**Re: Full application for the erection of 58 dwellings and associated works at land at Dodworth Road, Barnsley, South Yorkshire on behalf of Bellway Homes PLC (LPA application ref. 2010/1098)**

Further to our telephone conversation today, I enclose revised layout plan PL02 Rev E which has been amended to take into account comments from the applicant's Highway consultant. For completeness, I also enclose my explanatory email from yesterday which describes our response to the Highway and Urban Design comments provided on the 10<sup>th</sup> November.

Further to Chris Calvert's letter of the 6<sup>th</sup> November 2010, we have revised the site layout to reflect the comments received yesterday from Highways and Urban Design and attach Rev D layout. The amendments to the layout and, where relevant, our response to the Highway and Urban Design's comments are as follows:

Job No. 10-024  
Drawing No. PL02  
Scale 1:500  
Revision B

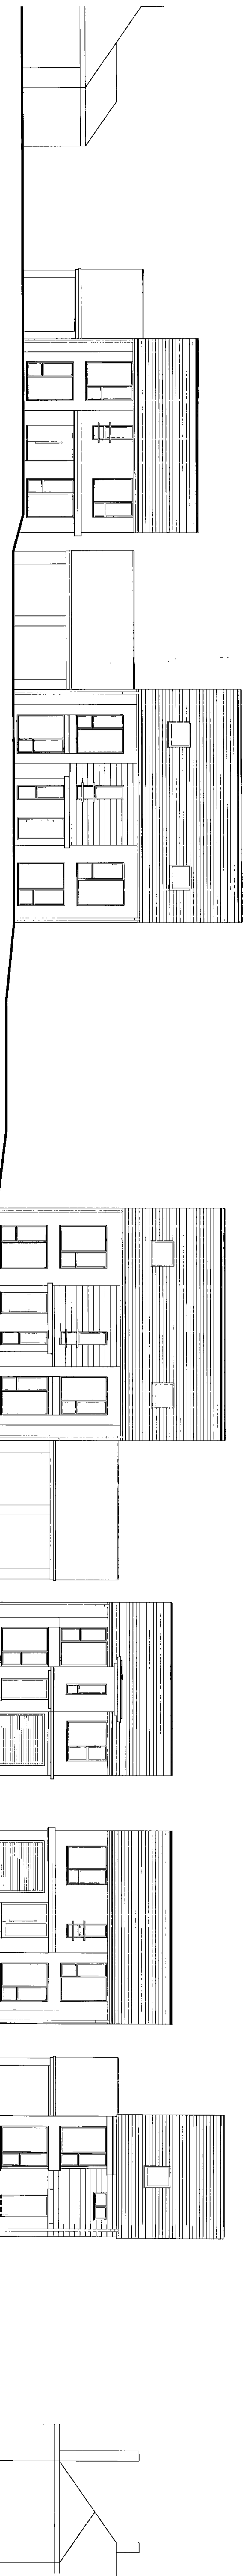
- *6m radius kerbs should be used at junction*  
*Actioned*
- *Shared services should be 5.5m wide unless there are no stats to be accommodated*  
*Actioned*
- *Extend turning head slightly to red line outside plot 31*  
*Actioned*
- *Square adjacent to plot 16 is big enough for a refuse vehicle but the egress manoeuvre cannot be done as there is insufficient reversing distance. Can be overcome by extending square slightly or probably by flipping it over so the narrower end is next plots 14/15 – this needs to be checked*  
*Actioned*
- *The cul-de-sac serving plots 1-14 is long enough to warrant a turning head for a refuse sized vehicle, needs extending to the red lines. Care needs to be taken that no part of the residential properties alongside are overhanging the highway.*  
*Actioned*

- *The loss of two trees on one corner of first road 'square' feature as you enter the estate means that you completely lose the balance of this feature. This is an important positive feature of the estate and some way of regaining its balance should be found.*

- The rear garden boundary of plot 16 and the side of this house should not be immediately on the back edge of the pavement, as this will appear too jarring- it needs to set back further as occurs with plots 46 and 47.  
Actioned

- From a design viewpoint I much preferred the previous kink in the road by the public open space to the rectangle square now shown. The open space has gone from a flowing space giving views across to plot 1 and beyond to an odd looking 'stump' which really does feel like 'left over space' and which will get a footpath rut developing through the grass along the desire line which now cuts across it.  
Actioned.

- Now that plot 41 has been clarified as a Piccadilly house type (before it was labelled 'B') it emphasises even more how many dwellings on this stretch have integral garages, between plots 41 and 17, on the outer sweep of the curve so they will be particularly noticeable. There should be more variety of house types to include properties without integral garages here.

- There is one three bed property with too small a rear garden- plot 38 (47.5sqm compared to 60 sqm).

- Despite the justification of the applicants I still consider plots 51, 52 and 53 to have poor front views and this affects their residential amenity.

Actioned - Area reworked to introduce additional tree pit.

We initially amended this area in line with highways comments which required a clear termination of the 6.5m highway through use of a turning head before resuming vehicular access along a reduced width shared surface. Further comments have necessitated a reworking of this area. In doing so we have attempted to address the aspirations of both the highways and urban designers by accommodating the required turning and smoothing out of pedestrian design lines to negate 'ruts' forming through landscaped open space. The turning head has a concave edge adjoining the landscaped central feature as a transition device between rigid highway and organic landscape and shared surface.

Whilst we agree that there are a number of properties with integral garages on this stretch of road (not more than 3 in row) we would strongly disagree that this has negative impact on the street scene. We are not proposing a town house scenario of garage door / door / garage door etc. It is our opinion that the submitted visualisations clearly demonstrate that each house has generously proportioned full height glazed windows to habitable rooms at ground floor (and first) that overlook the public highway. These will facilitate excellent interaction and animation between street and dwelling and as such, we believe, will be perceived as the dominant feature.

Actioned. The garden area has been increased to 55sqm.

We reiterate our justification. This portion of the site falls within an internal corner of the site and remains a consequence of pursuing the design diagram of creating individual zones within a holistic framework. It is our interpretation that this area is a small enclave fed off a private block paved drive. The outlook is of occupiers own garages / drives, a garden fence (11m at its tightest to 17m away) beyond which there are mature gardens and long views to the tree belt. The property adjacent plot 53 is not residential use and is single storey.
